Application number: 2025/0568

Description: Lawful development certificate for proposed change of use from garage/storeroom to residential flat

Location: 166 Barnsley Road, Darfield, Barnsley, S73 9DQ

| DRAWING TITLE:  | Combined Plans  |

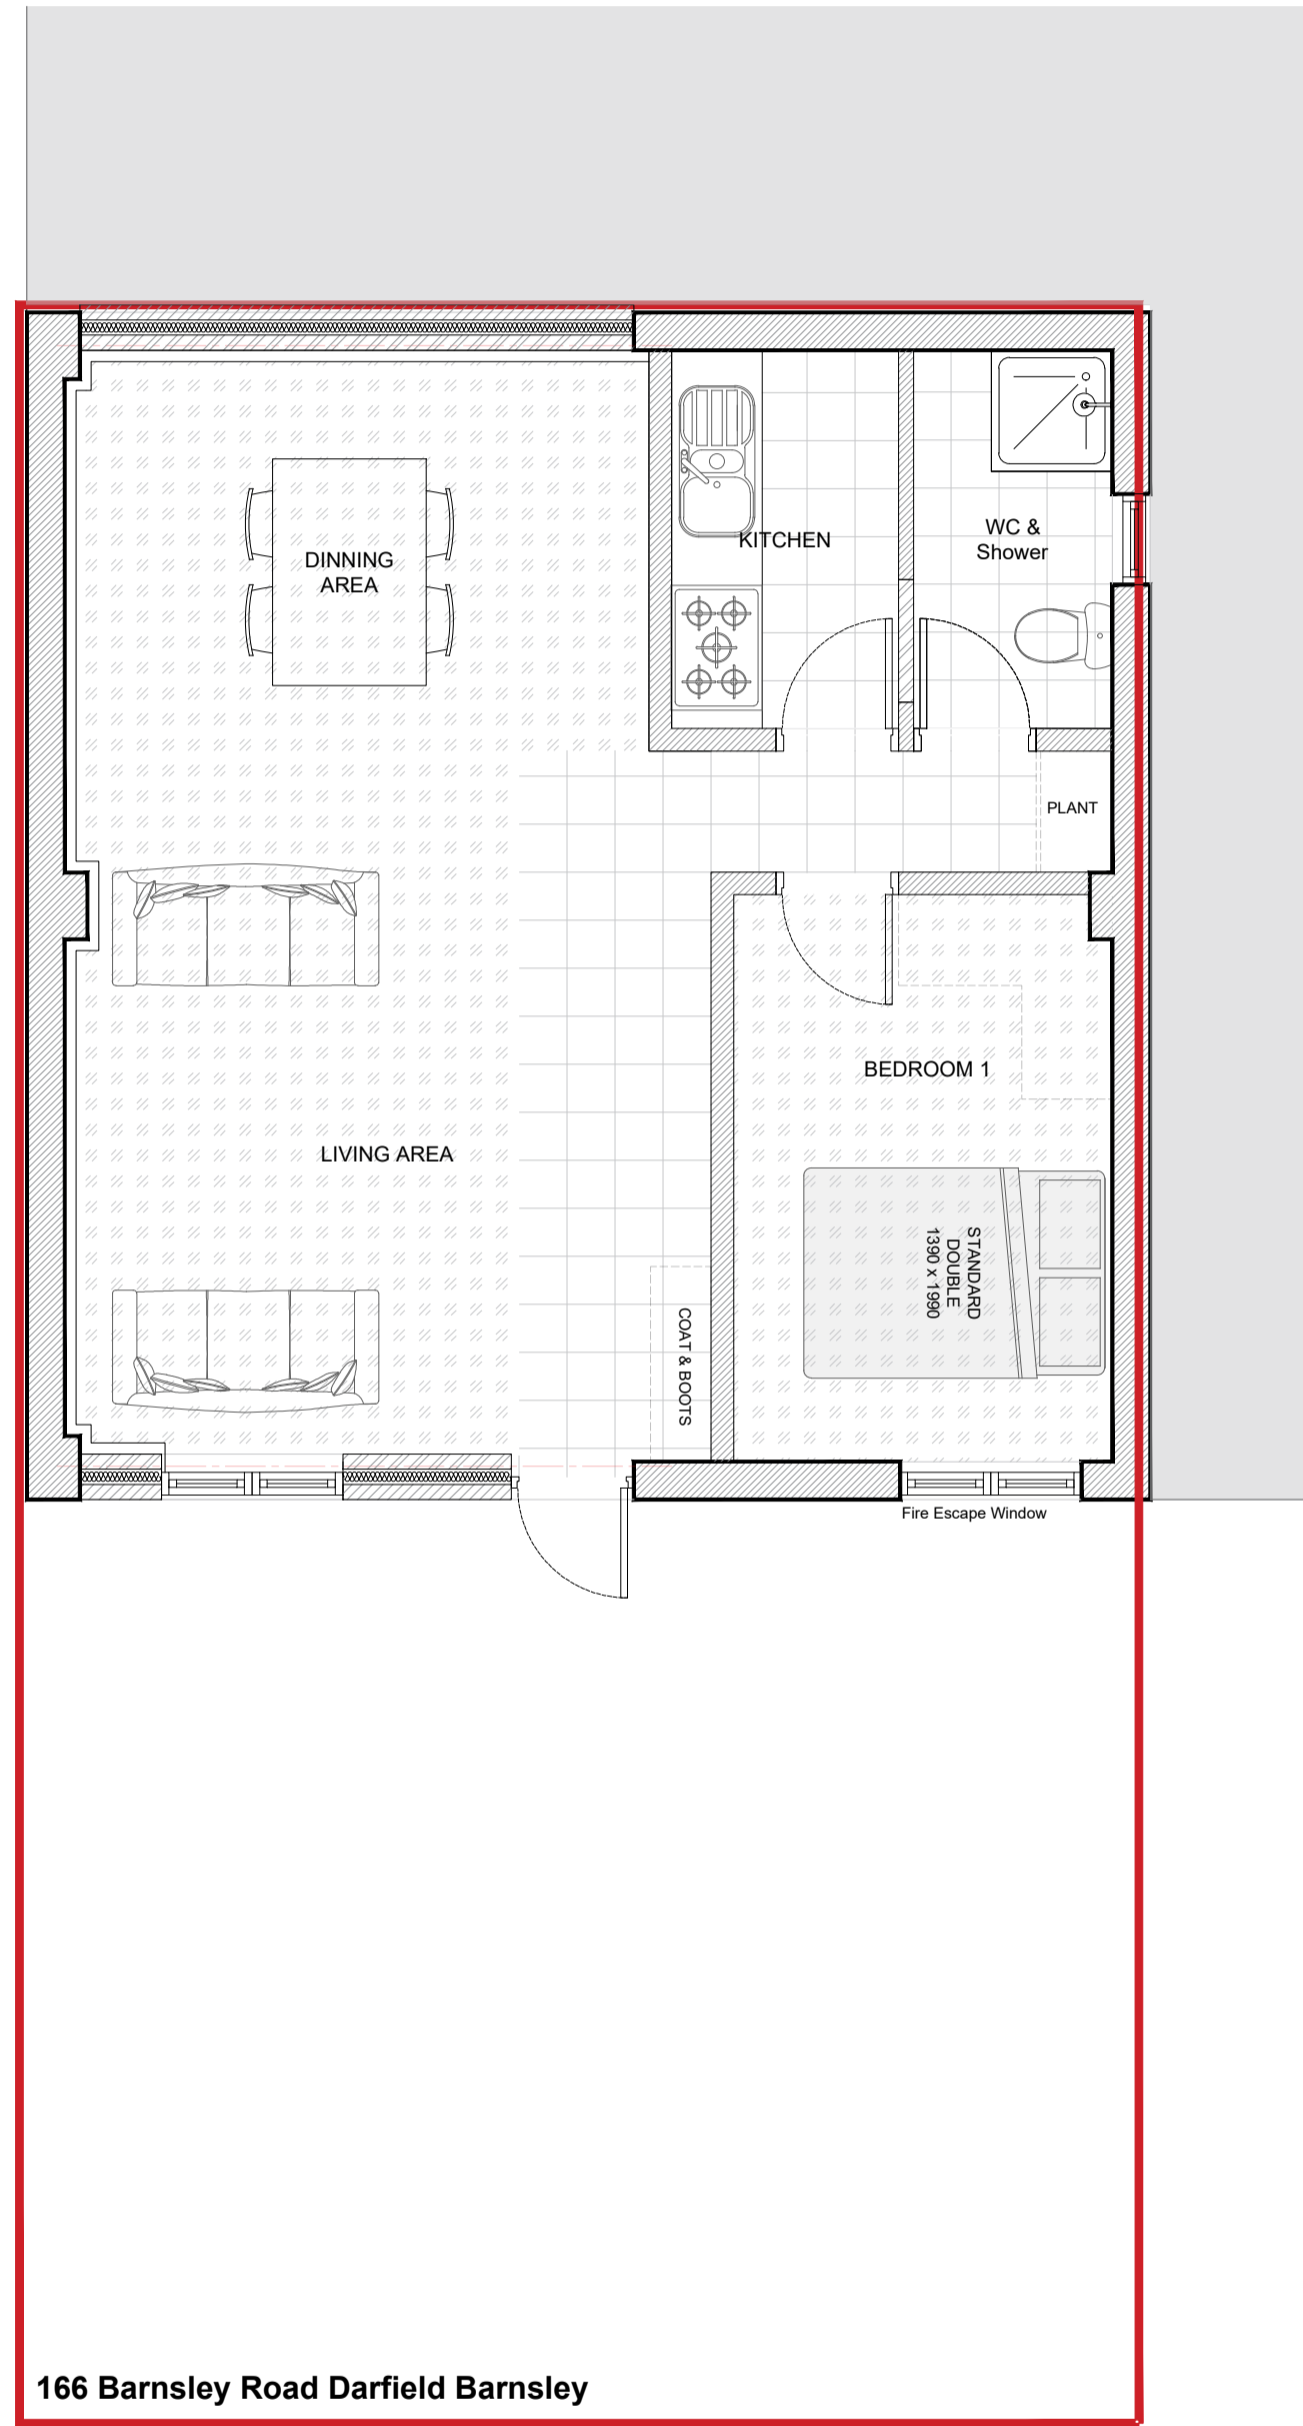
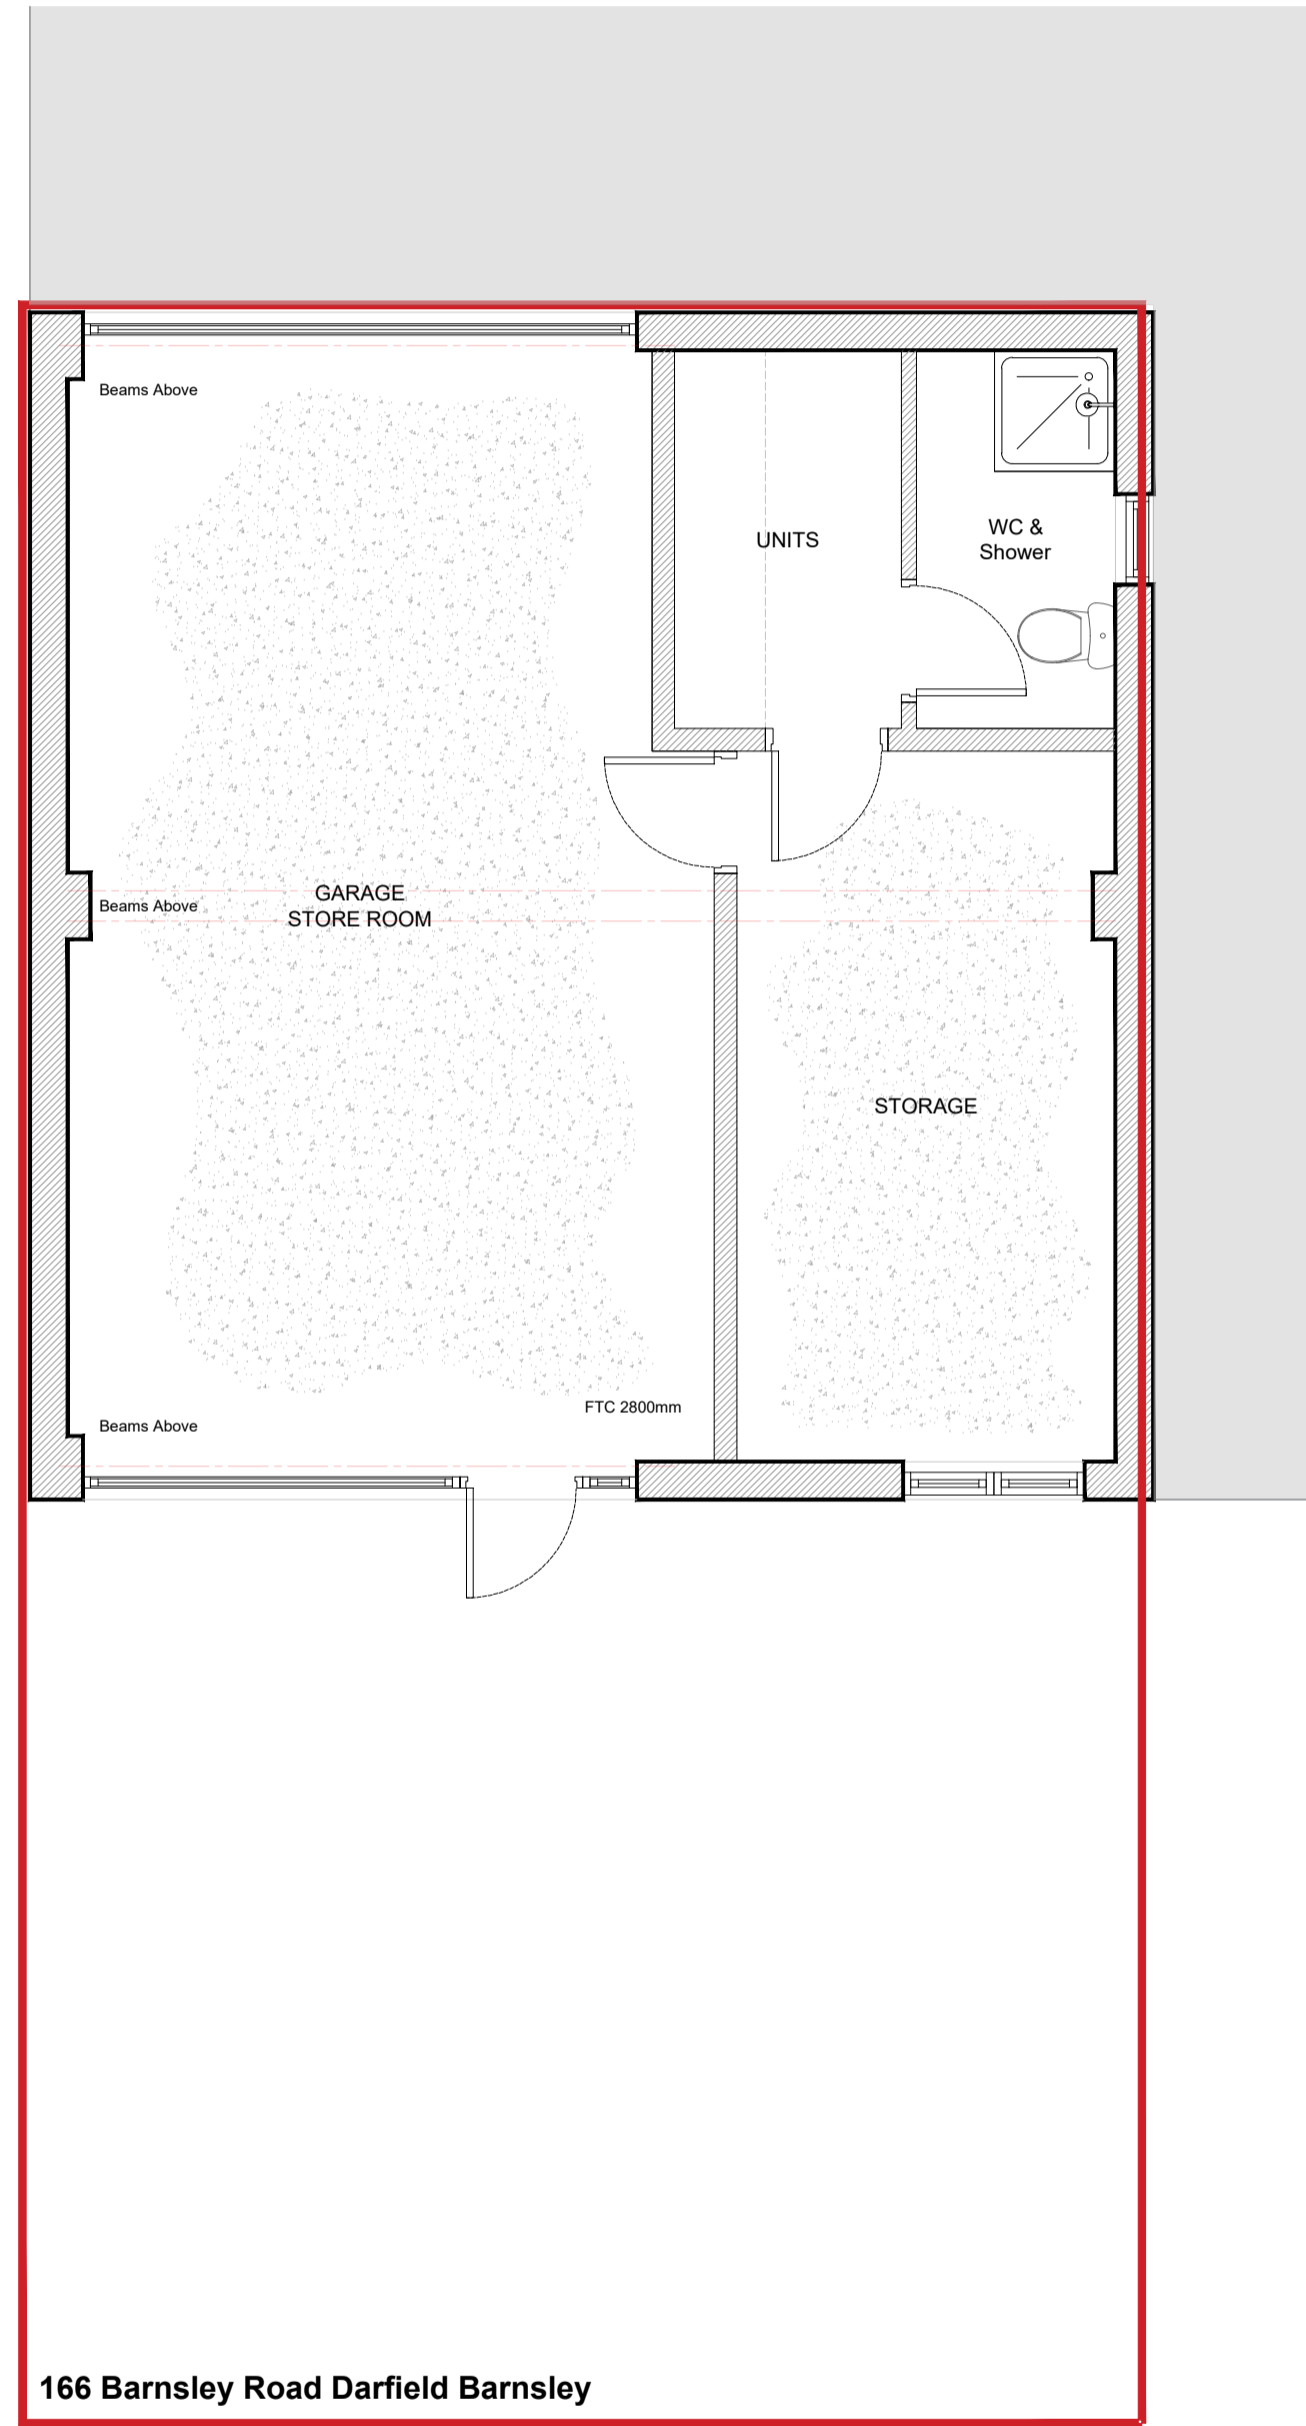
The applicant has provided no justification for why planning permission is not required for this application. The applicant has provided plans with a redline boundary around the ground floor which is currently used as garage/storage room and includes the driveway which serves the whole property of 166 Barnsley Road. The change of use would therefore lead to a loss of parking for the larger residential property of 166 Barnsley Road. Therefore, leaving the larger family dwelling with no parking. The proposed flat would be a separate entity from the rest of the residential dwelling, and as such would require private amenity space. The applicant has not provided this either.

The plans which the applicant have provided show the development as a self-contained flat with its own entrance, kitchen, and bathroom and thus would be a separate dwelling that would be in the curtilage of the original dwelling.
